Re_Residential Subdivision Proposal at Moonee Beach

Ref# SSD 15_7198

From_Roger Barker

Figure 5 Proposed Plan of Subdivision

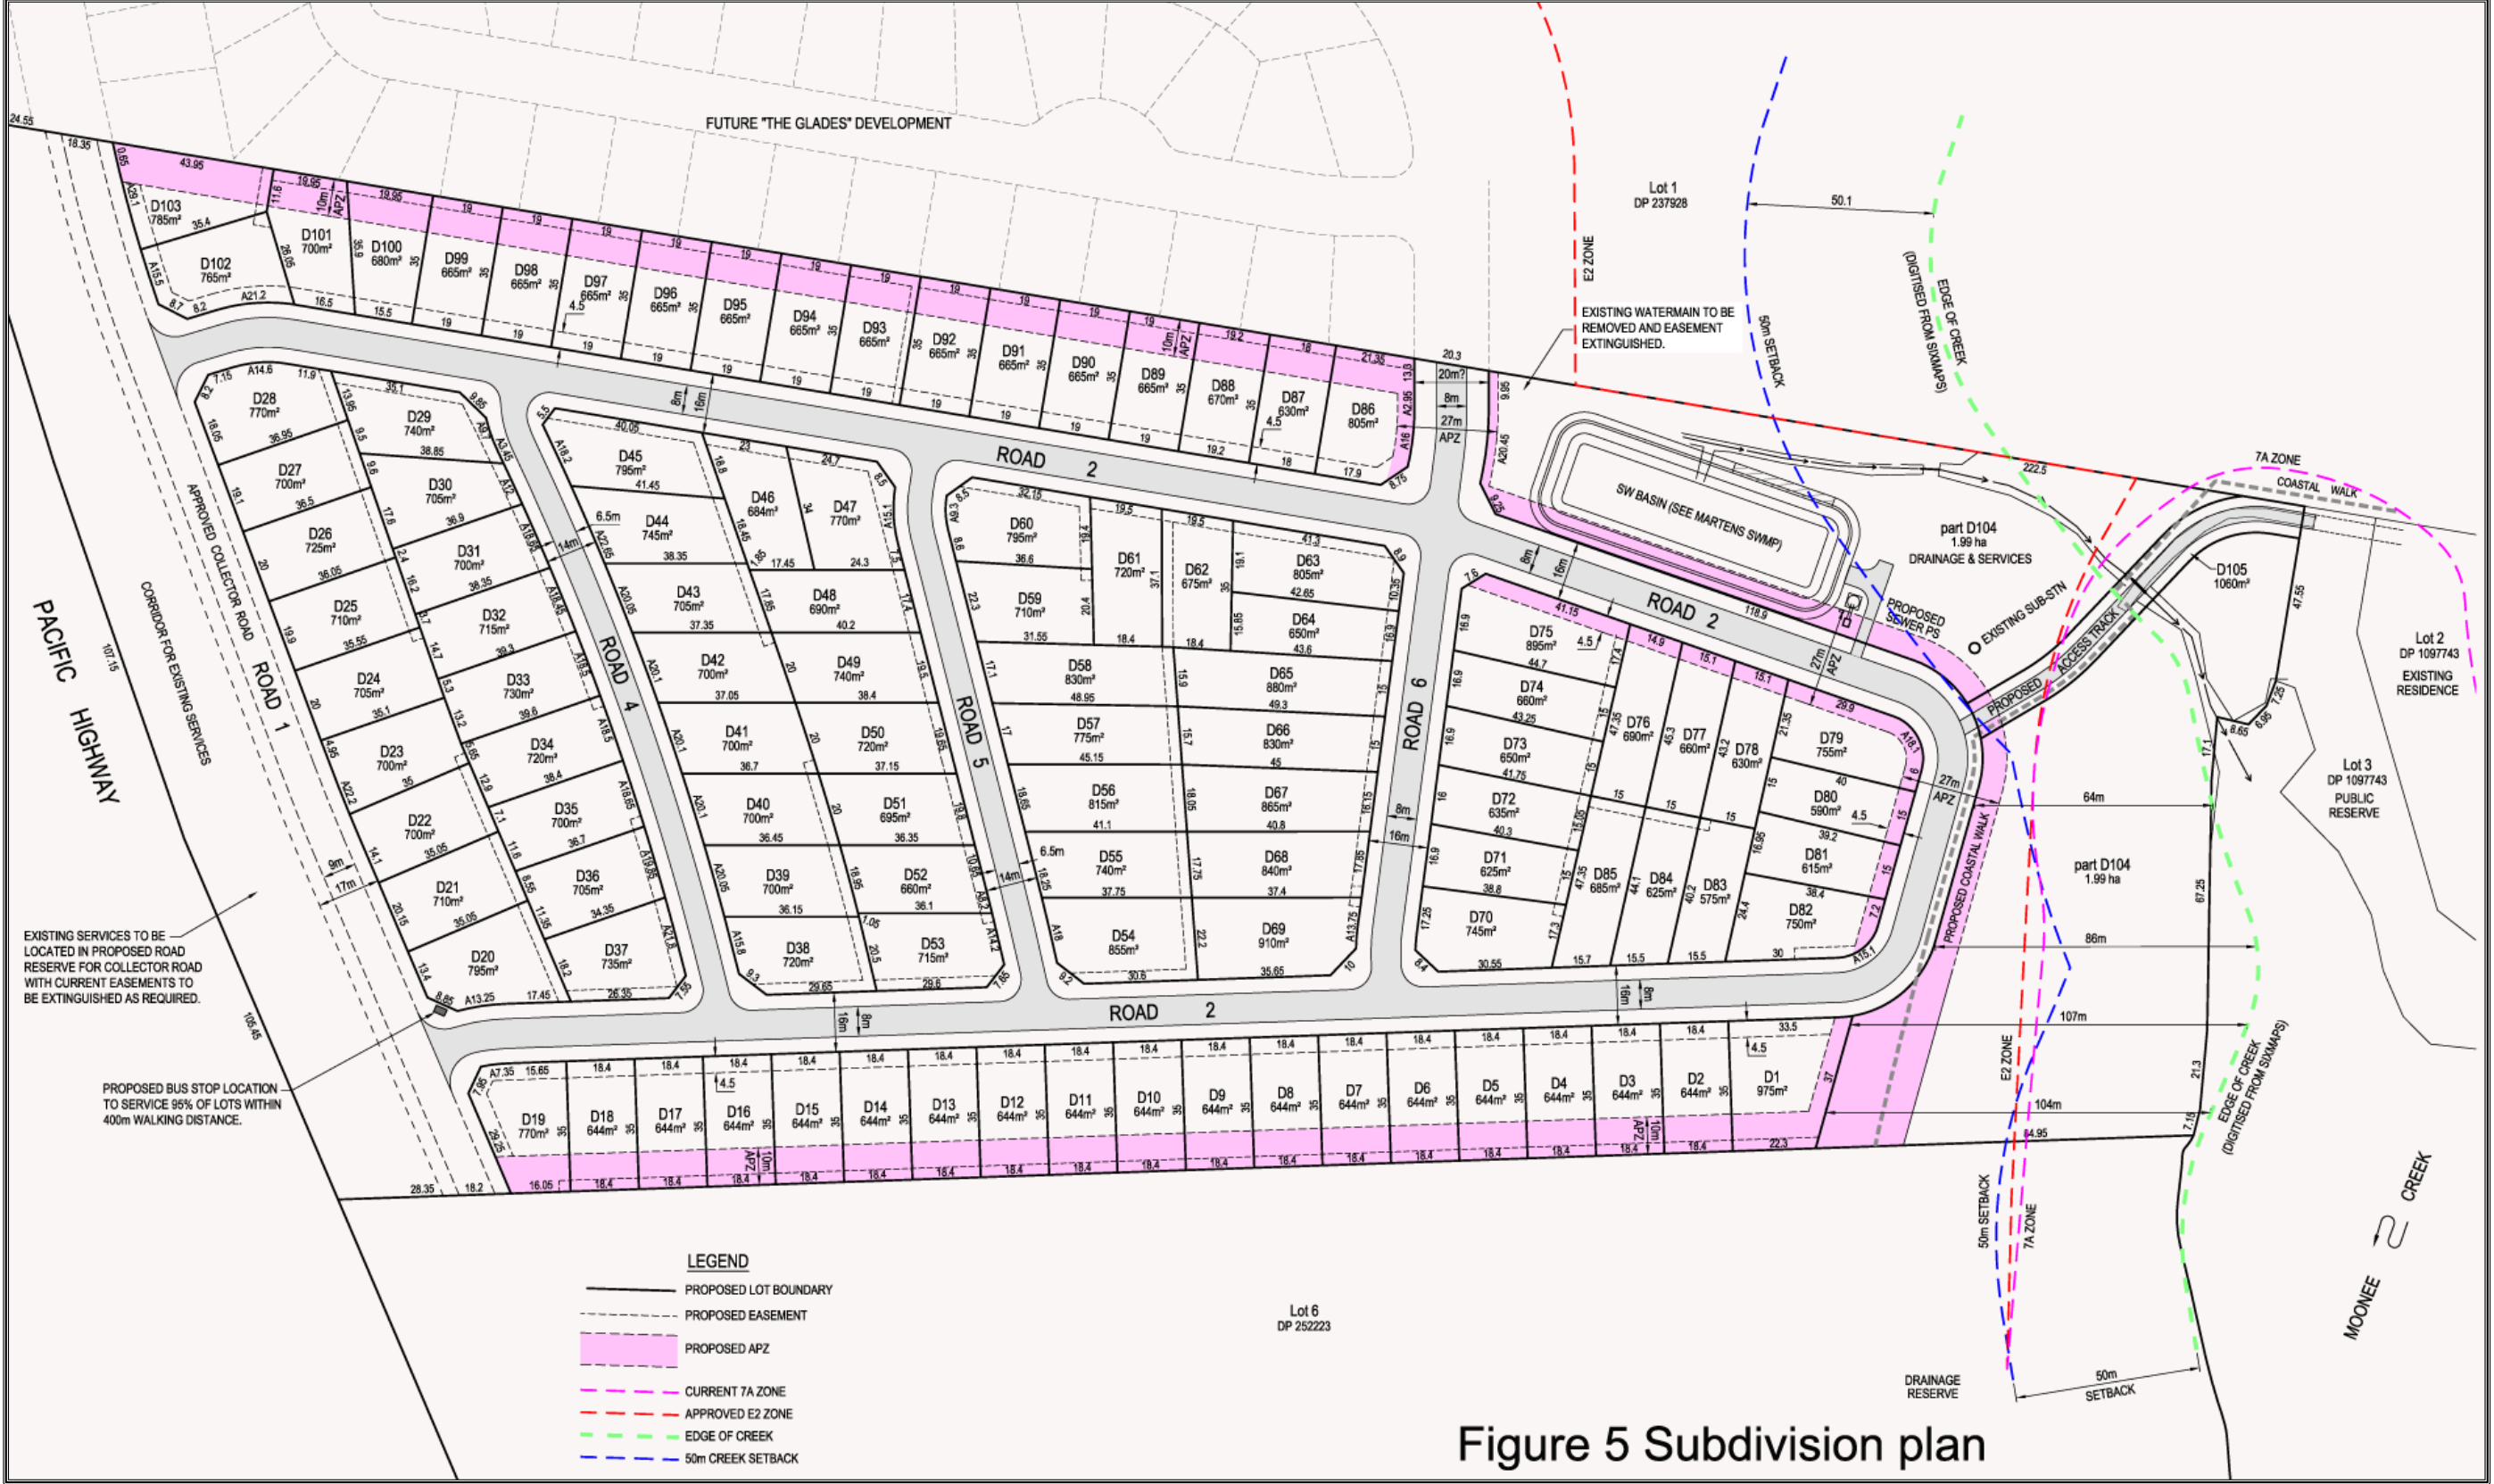
1/ The proposed plan is too close to Top of Bank at the Eastern perimeter Rd alignment. Will this be checked?

2/Perimeter Rd linkage to Sth East is required by DCP04, the same as it requires a walking track collectively around developments. Will this be rectified?

Figure 7 Earthworks Plan (Blue = fill/Pink = cut)

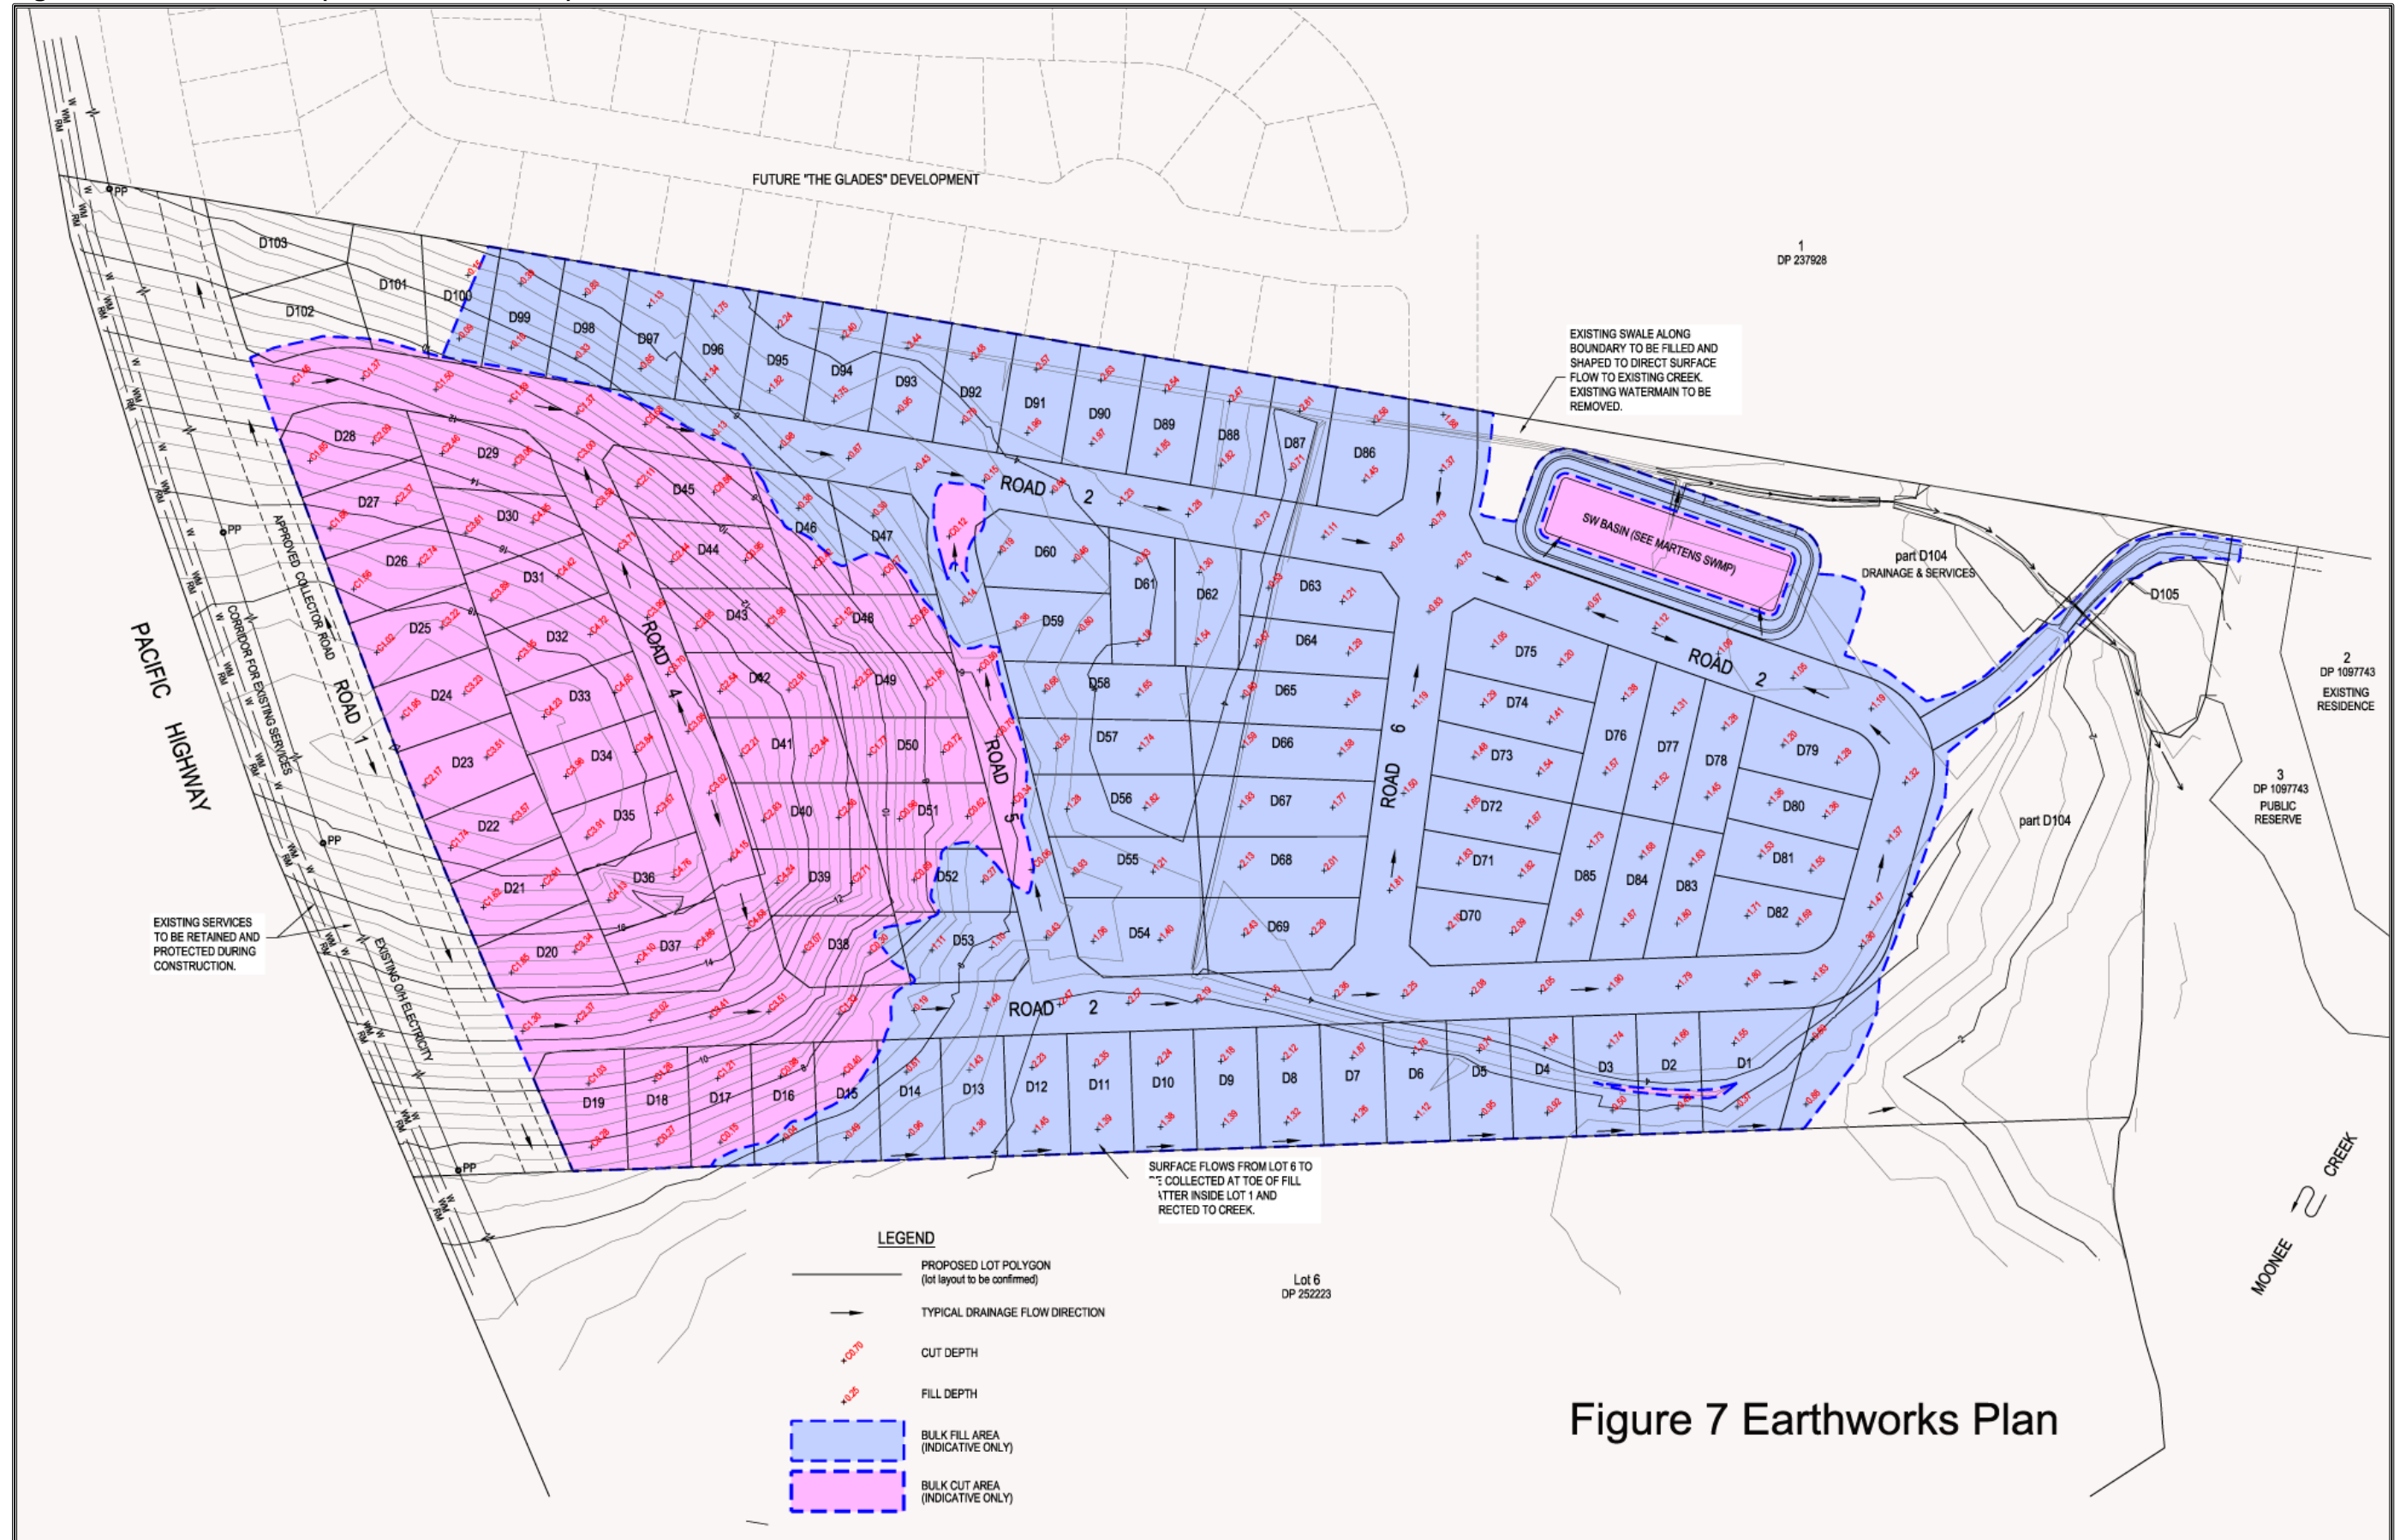
Does DPE require accurate detailed plans, prepared to scale, to properly assess Cut and fill contours proposal and drainage proposals? This proposal does not compute against accurate contour mapping!

- 1/Relic Mine shaft is not provided any due regard
- 2/Bore hole 14- why terminated at 700mm when latest report states all Bore holes to 4mtrs? Has the DPE allowed this on other projects in region?
- 3/Cut and fill proposes misleading inaccuracies, beginning with initial survey of heights.

Figure 9 Stormwater Management Plan

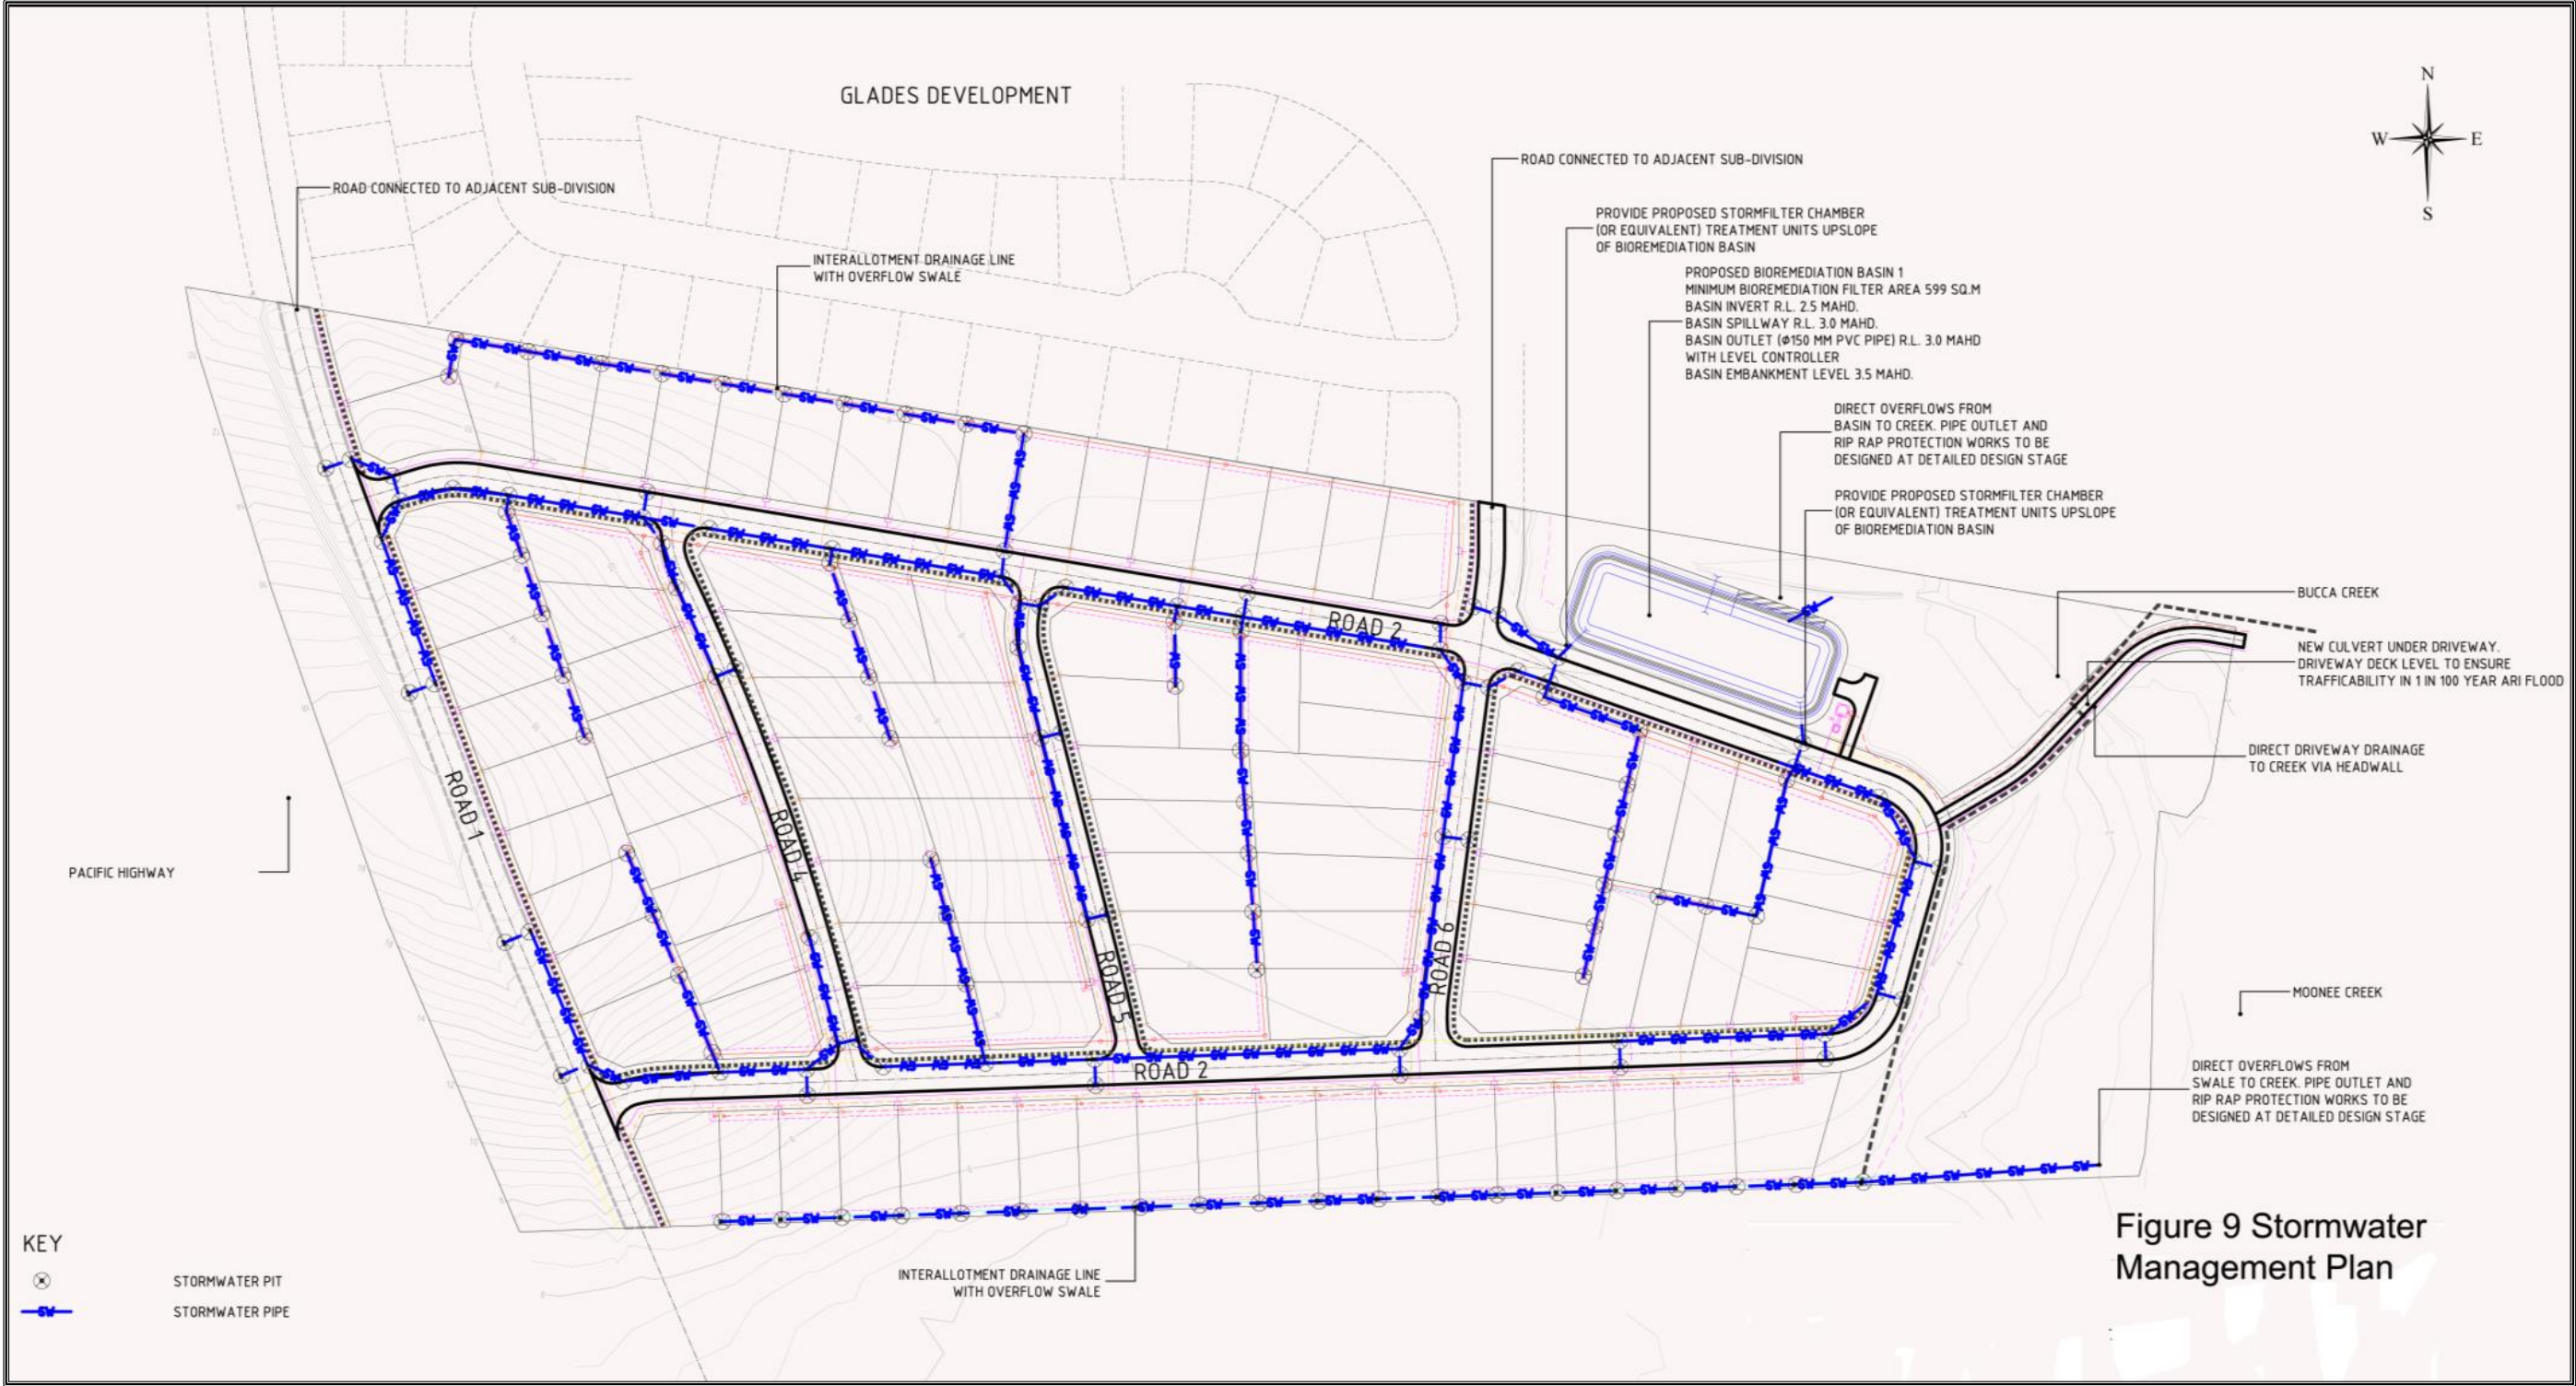
I disagree with functionality of the Sthn swale drain concept.
Given the altered catchment for Sthn storm water , and lack of fall available at Sth boundary to drain West to East at the foot of proposed slope, a retention pond should be required to prevent adverse impact on Sth neighbouring property. The drainage swales at foot of proposed Sthn slope are being proposed with minimal detail, inaccurate and not to scale, but show filter traps leading overflow into my property. To which I object.
Is it not prohibited to drain water to adjoining properties?

- 1/Sth drain-no detail - High risk inundation of Lot6, threaten transfer of proponents wetland.
- 2/Sth detention pond needs reconsideration outside of Buffer (sacrifice 1 or2

lots on Sth Boundary and save a few trees at the same time)
 3/Sth drain should be of adequate dimension and declination so as to not over flow into lot6 DP 252223
